Our Case Number: ABP-314942-22

Re: BusConnects Lucan to City Centre Core Bus Corridor Scheme
Lucan to Dublin City Centre

Observation from Senator Mary Seery Kearney
Seanad Éireann,
Leinster House,
Kildare Street, Dublin 2.

Reference: 314988 Core Bus Corridor from Lucan to City Centre

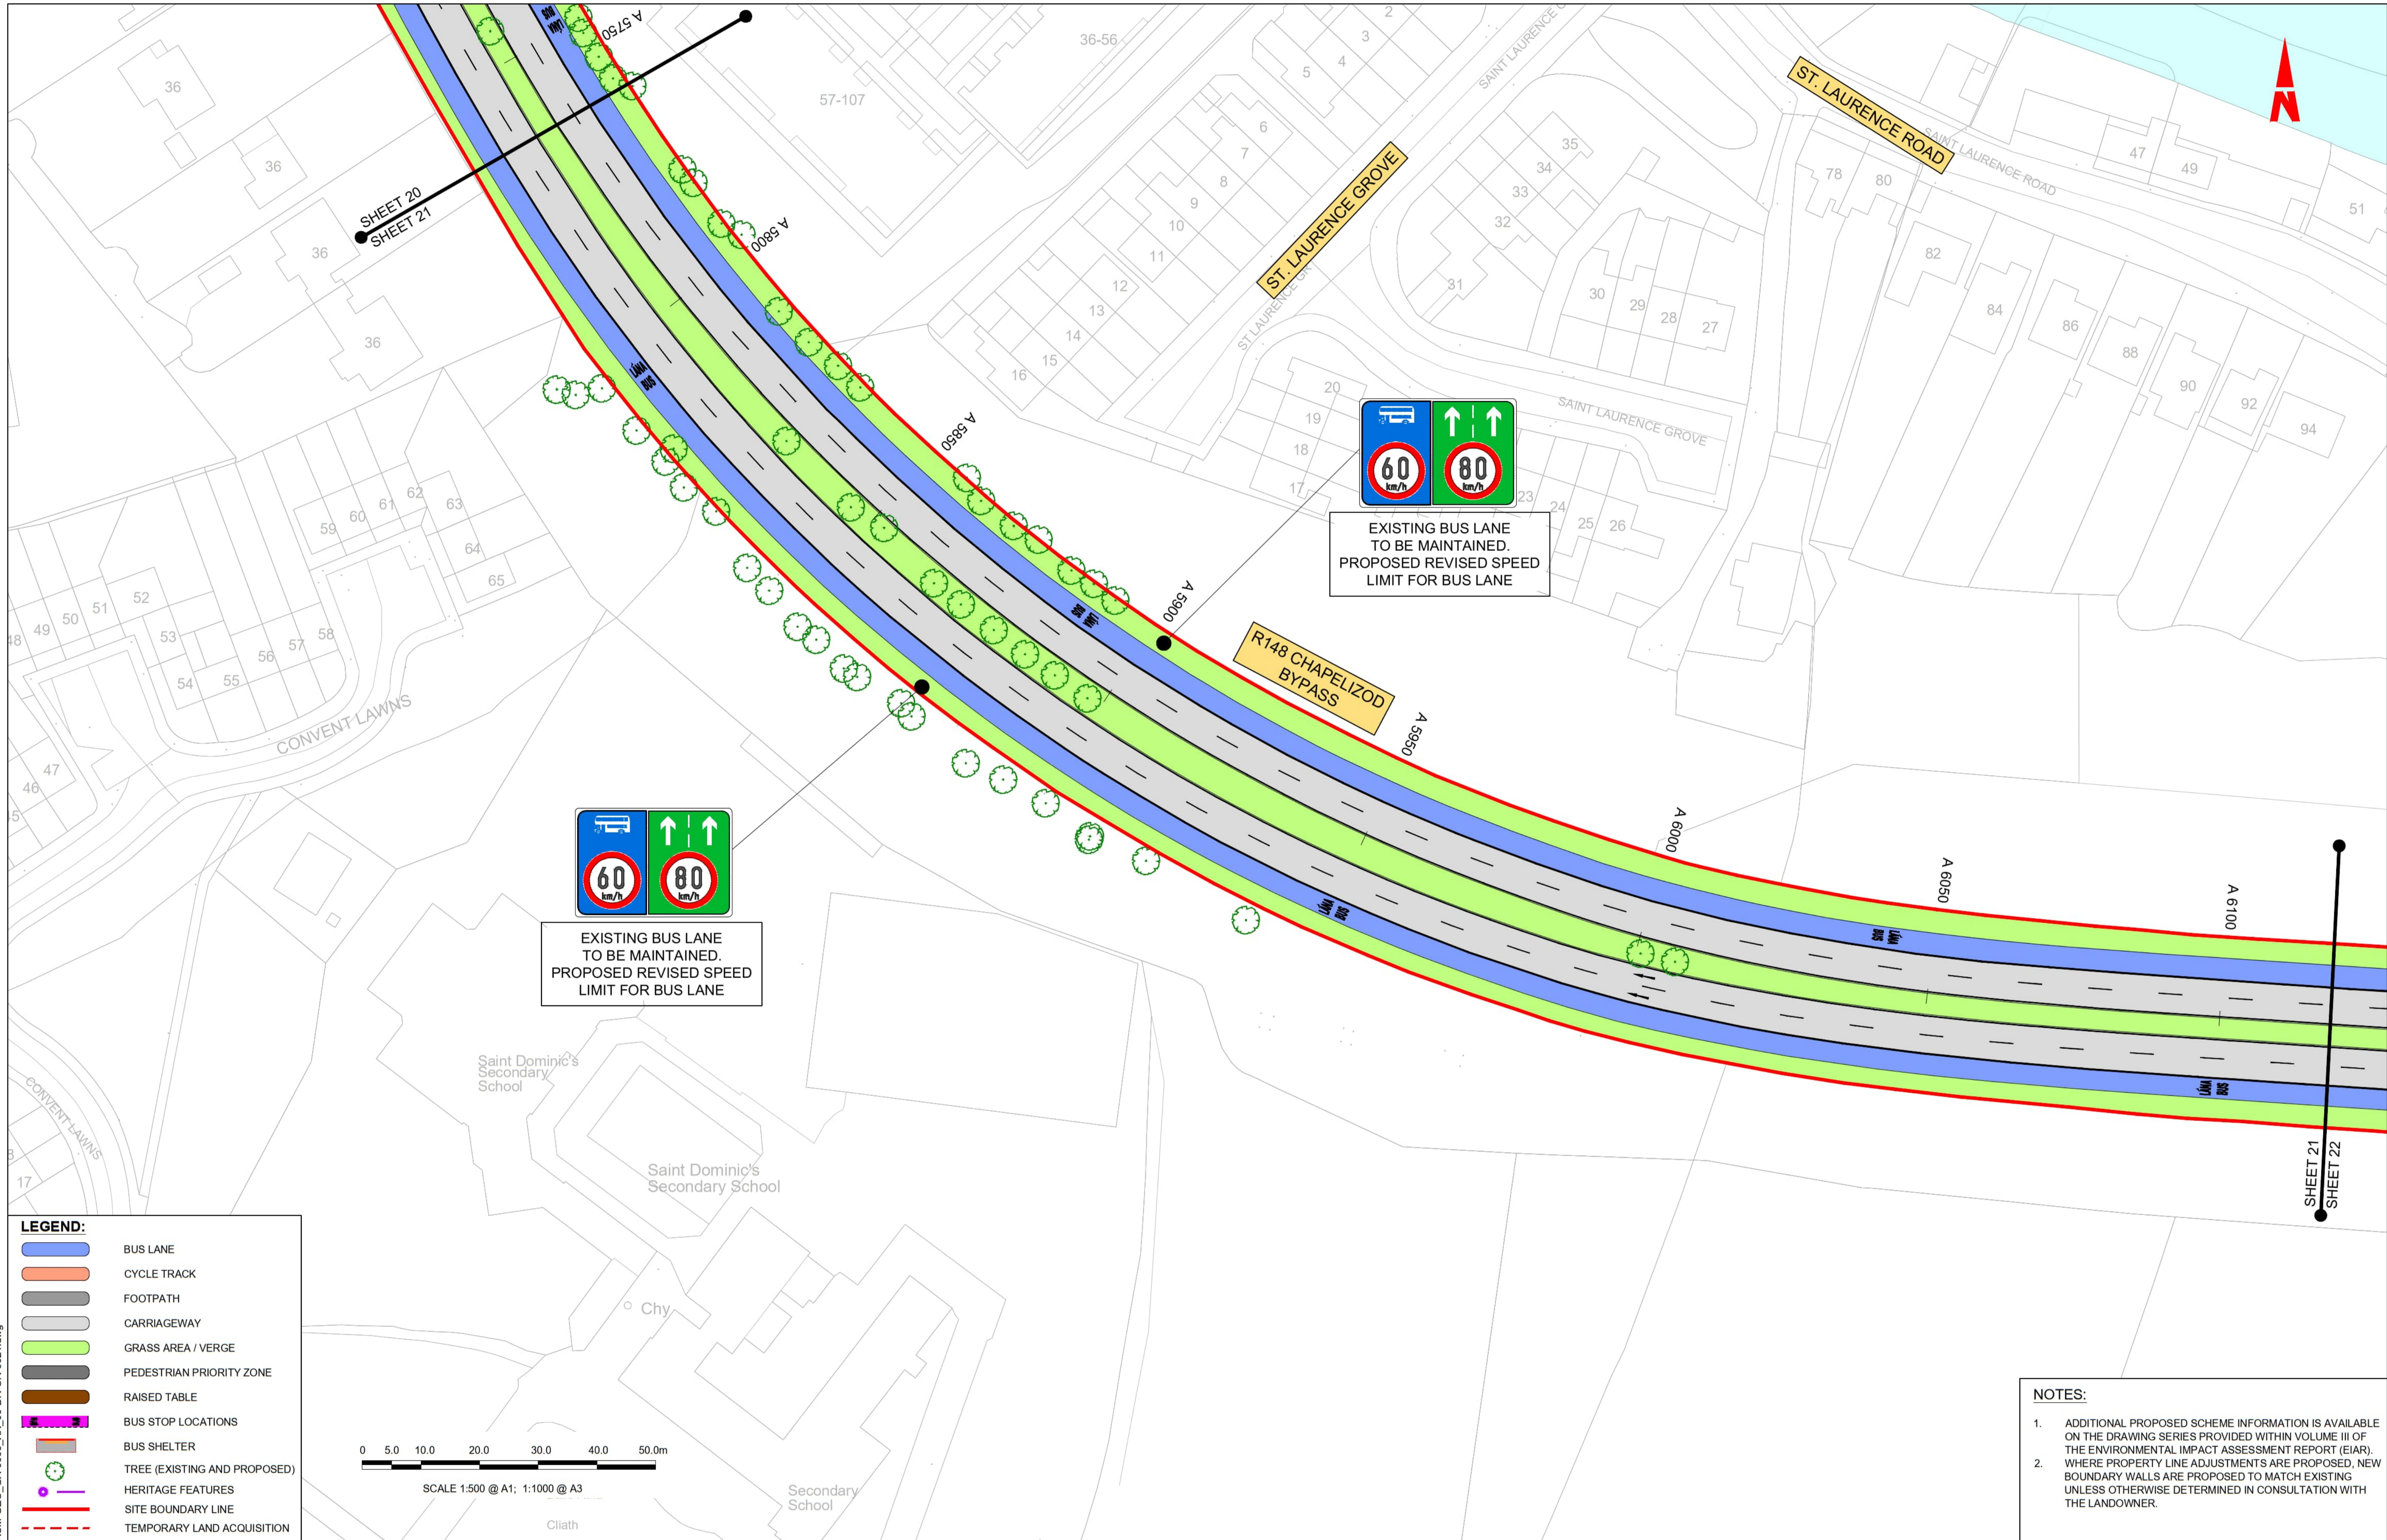
This essential infrastructure is the subject matter of section 5.5.4.1.2 construction methodology description, shown on Sheet 20 in the General Arrangement Drawings. It details the provision of a pedestrian ramp and stairs, the widening of the Chapelizod Bypass to create the bus stop laybys on either side of the Bypass. The work is proposed to take 6 months to construct.

I have absolutely no objection to this essential infrastructure. My ask is that An Bord Pleanála impose a condition that obliges the prioritisation of these works and ensure so that they are completed at the earliest possible time within the work schedule for this corridor.
